**Description:** Internal alterations and installation of extractor flue

**Location:** 20 High Street and 2 Albert Street (ground floor)  
Holbeach  
Spalding  
Lincs  
PE12 7DN  
PE12 7DN

**Amendment:** Revised location of extractor fan (dwg. no. 1003.P1A and 1003.P2A)

# AMENDMENT RECORD SHEET - LIVE APPLICATION

1003 | P | 1 A

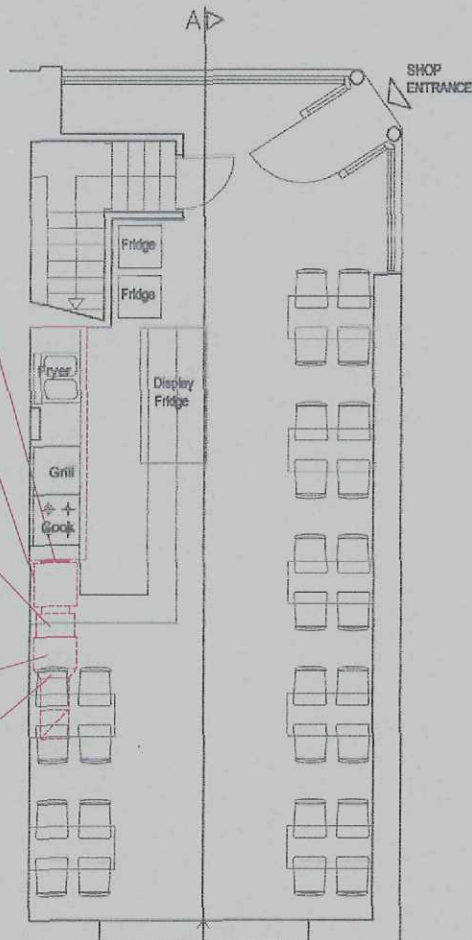
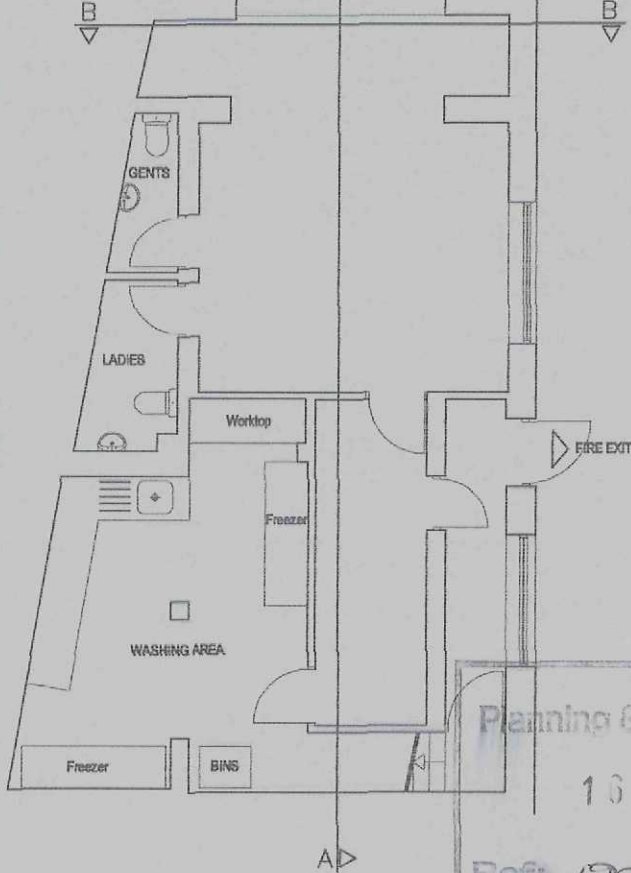
I believe that the position of the flue is as requested, but the method of getting there is not acceptable. Looking at the plans, you will be going through too many walls. I have attached the preferred plan, but instead of coming out the side wall, it should come out the rear wall of the modern extension. The flue pipe therefore only needs to move around the corner to be out of sight of Albert Street. Any problems, please come back to me.
